CLOVERLEAF SUBDIVISION

GRADING AND EROSION CONTROL PLANS

CLOVERLEAF SUBDIVISION
COVER SHEET
GEC PLANS

SWALE CROSS SECTIONS

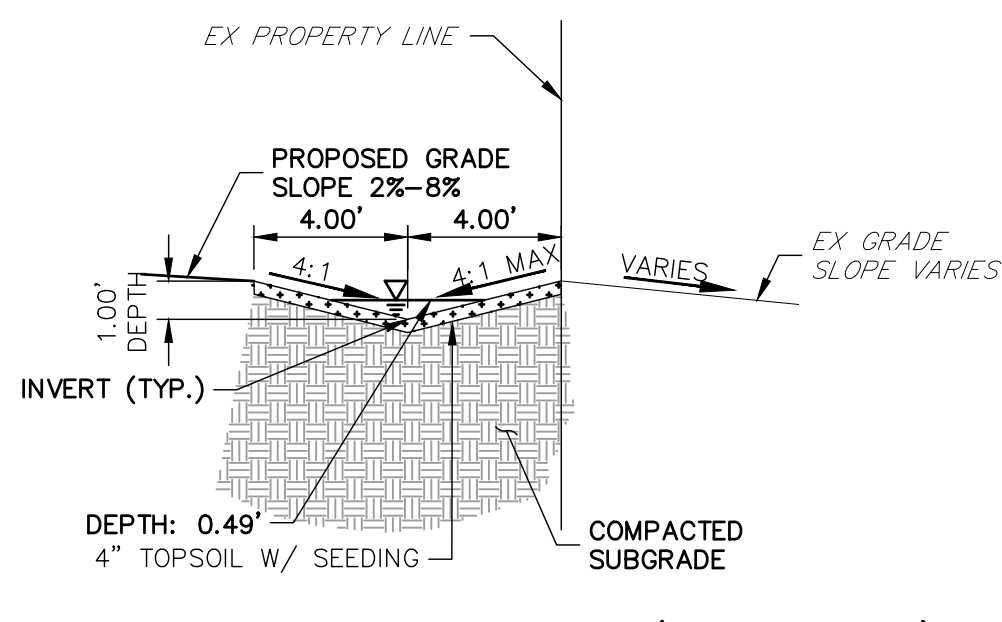
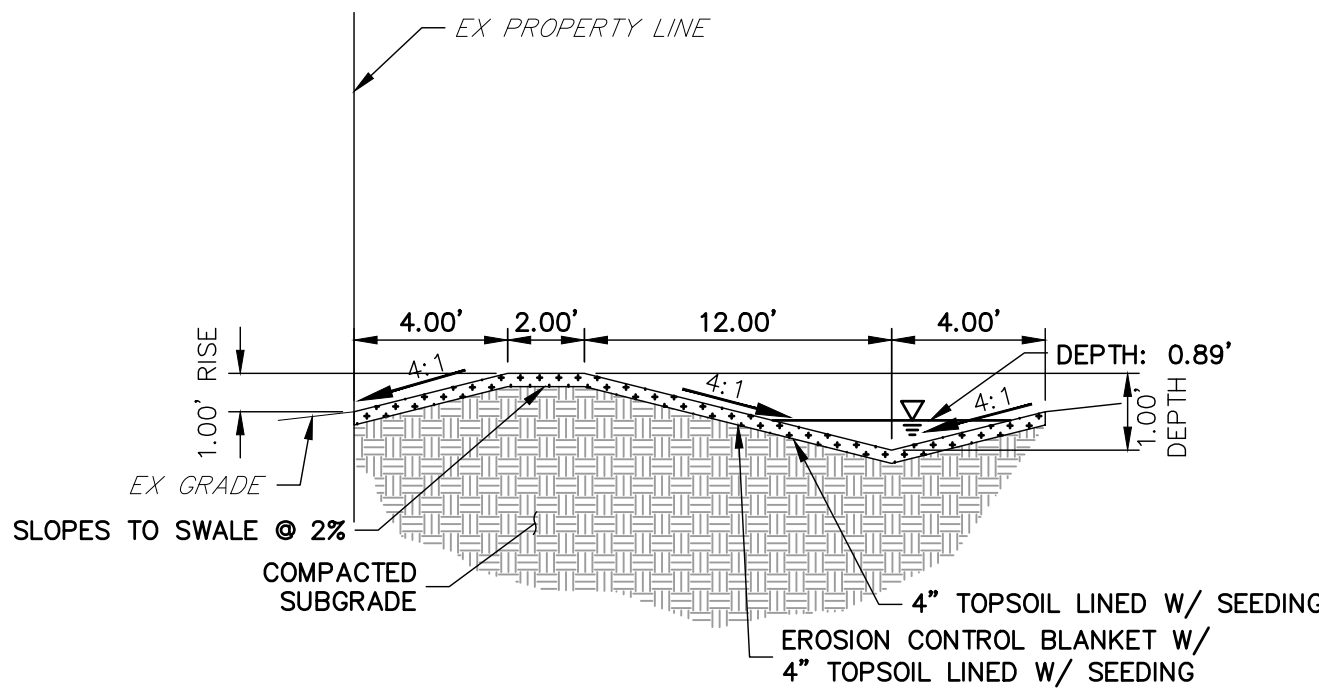
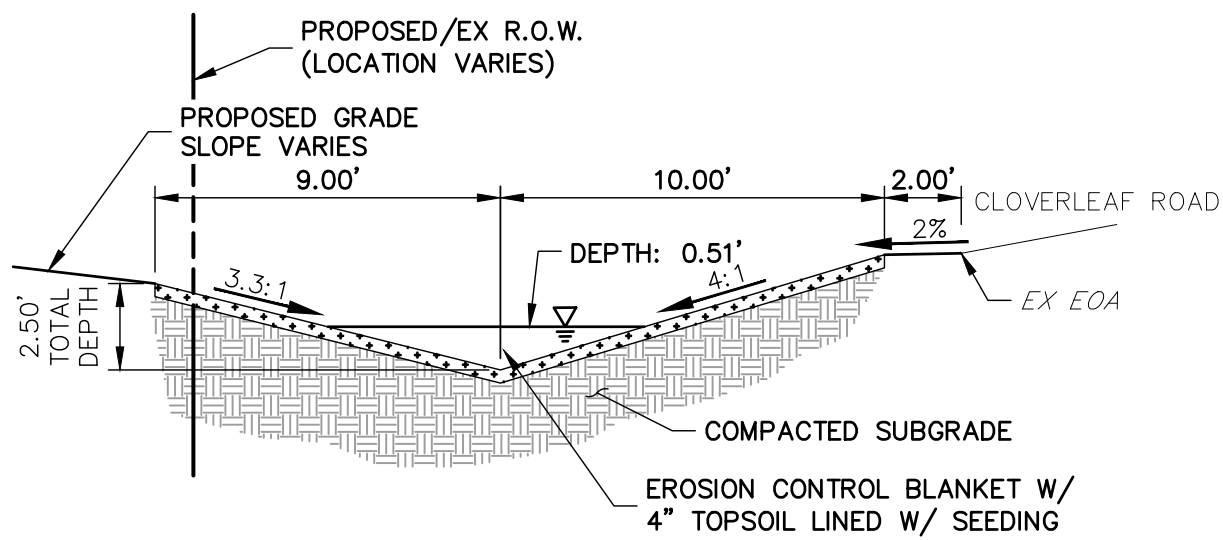
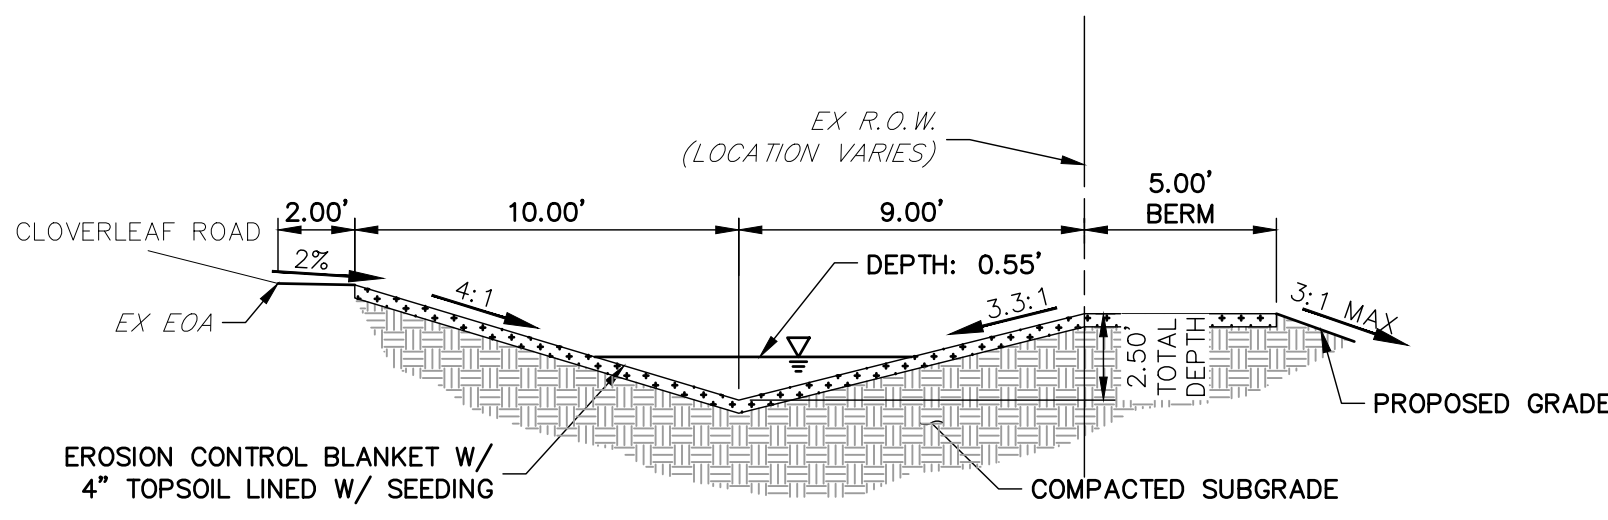
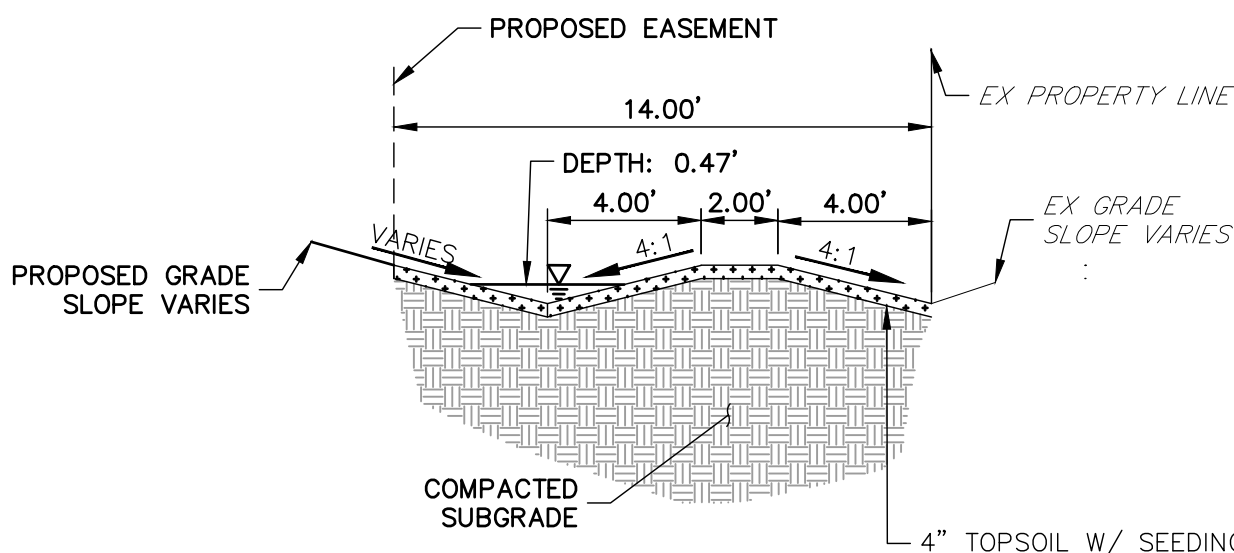
Revise. Per the standard road section (detail SD 2-11) the foreslope is 4:1. Show the property/ROW line location on the cross section detail.

Hydraulic calculations for the swales will be required with the final drainage report.

JR Response: Noted.
